Shoe Zone Retail Limited Humberstone Road Leicester LE1 2LH

Your Ref: BR/180/19/PL

We refer to the recent planning application and associated supporting documentation (the 'Application') filed by Clive Hawkins Architects Ltd on behalf of the Trafalgar Group (the 'Applicant'). The Application relates to the erection of a demountable commercial unit at front facing London Road with residential unit at rear (the 'Proposed Development').

Shoe Zone Retail Ltd ('Shoe Zone') occupy the retail premises at 31b London Road and are immediate neighbours to the Proposed Development.

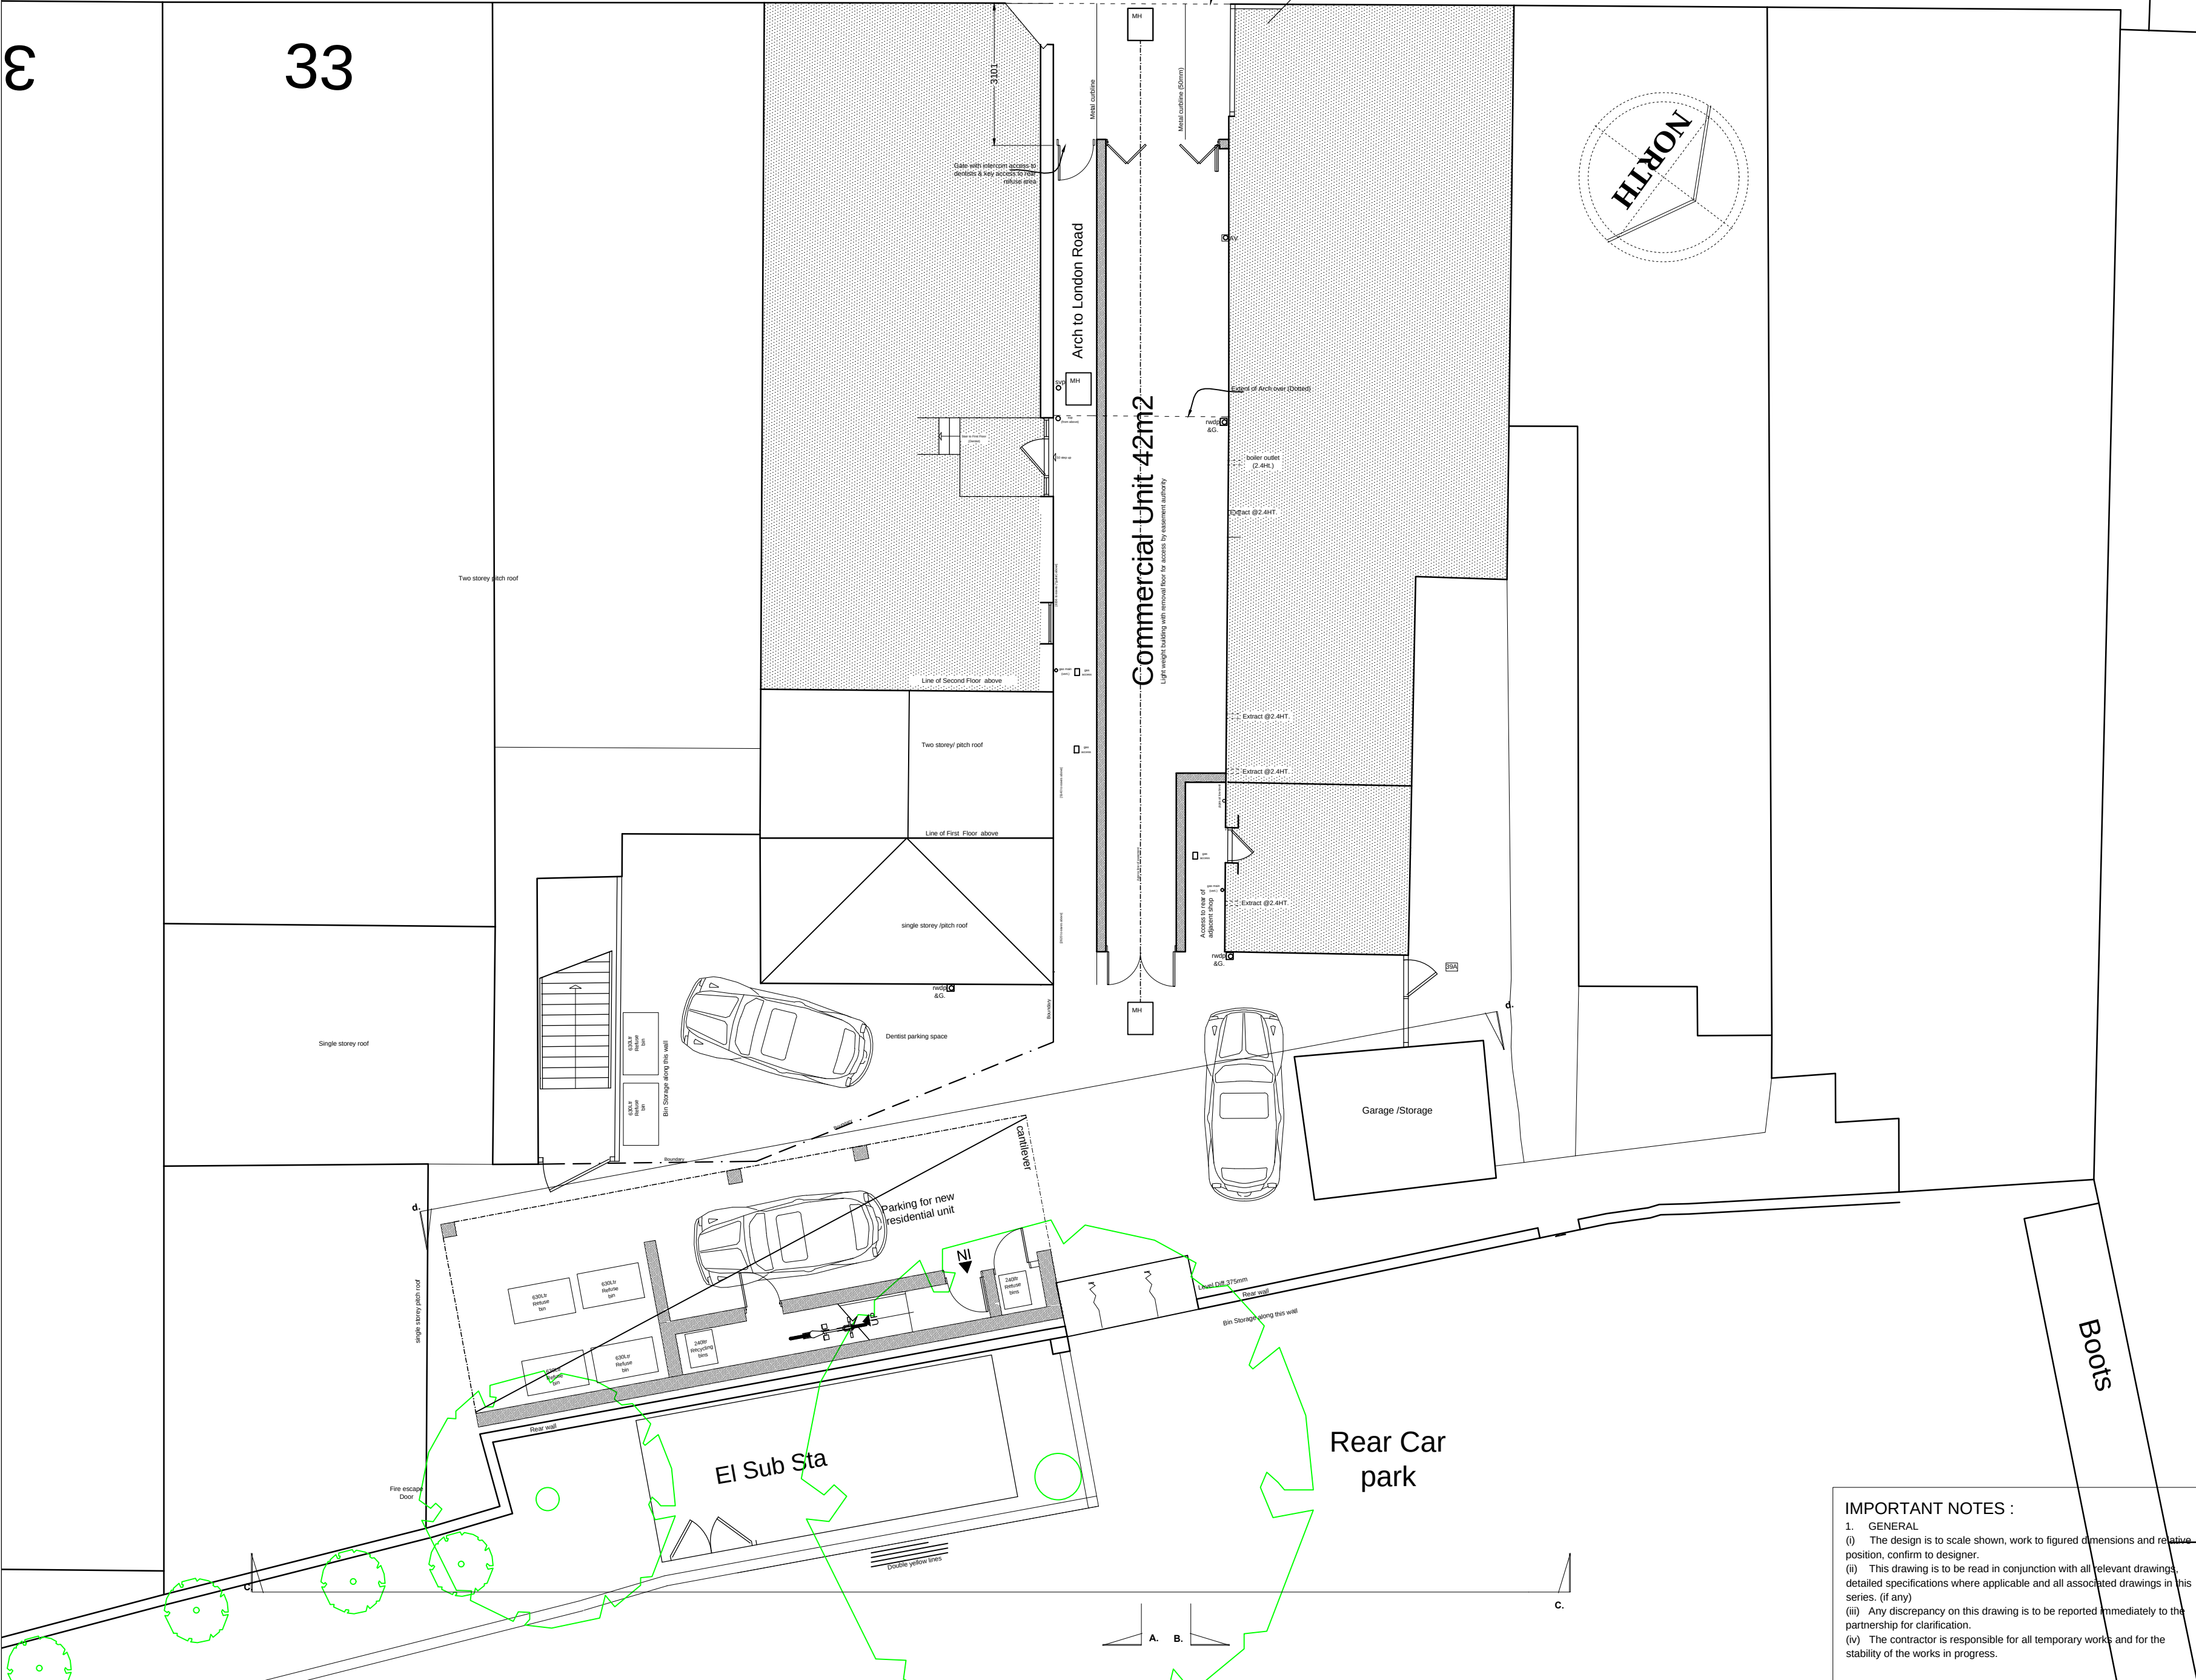
1. Access- Since 1980 Shoe Zone (and its predecessor companies) have occupied the premises at 31b. Shoe Zone has enjoyed a legal easement expressly granted by a deed over the land which the Applicant proposes to develop. We attach a copy of the lease plan from the most recent lease dated 13 April 2017, showing the accessway coloured brown (the 'Accessway'). Shoe Zone staff use this land as a means of access to and from the London Road and the rear area for deliveries. Given the width of the Accessway at the front and rear, it is unsuitable for a commercial and residential unit. The Proposed Development will restrict the Accessway significantly.

2. Health and Safety- the Proposed Development obstructs a designated fire escape route at the rear of our premises.
3. Layout and density of buildings- The Proposed Development is of an overbearing nature in its entirety. The proposed commercial unit seeks to infill the covered passageway from London Road entirely and, in particular the proposed residential unit as shown in Block Plan is almost touching the structure at No. 33. Introducing another

Dims added	Aug 19		A
Revision	Date	By	Rev. No.
Client			
Project RO 37 London Road, Bognor			
Title Block Plan			
CLIVE HAWKINS ARCHITECTS LTD DESIGN@CLIVEHAWKINSONLINE.COM Tel: 01273 245249			
Scales 1/500@ A4	Date 1.6.19	Drawn	Designer
Project No. 637	Dwg. No. Block Plan	Rev. No. A

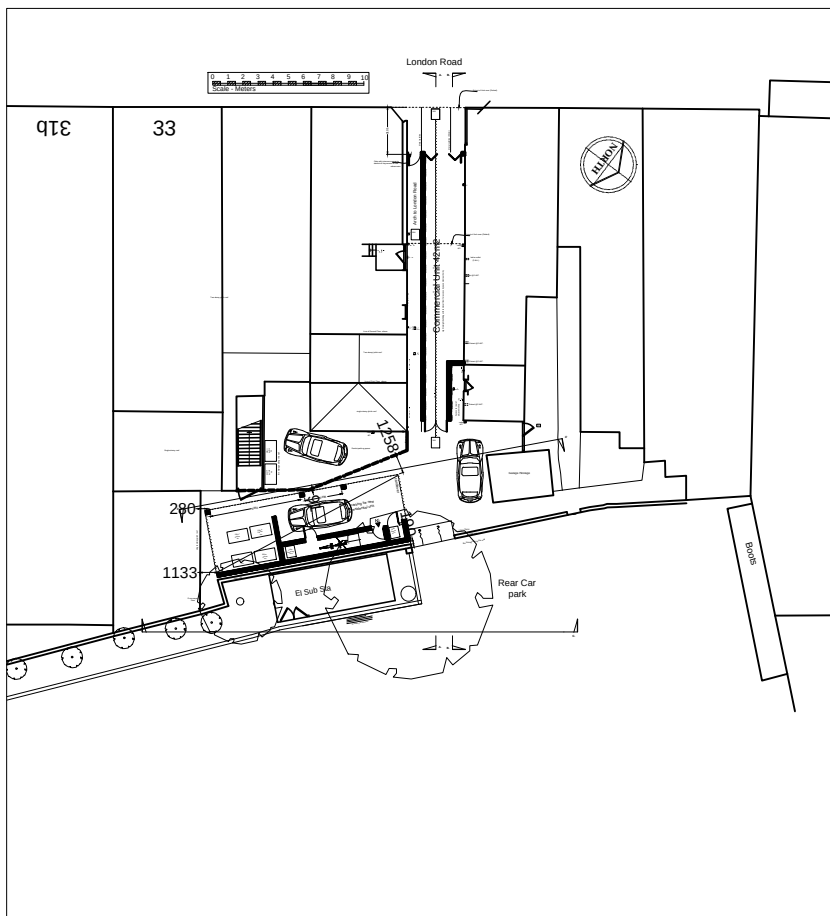
two units into this area would increase what is already an excessive concentration of buildings.
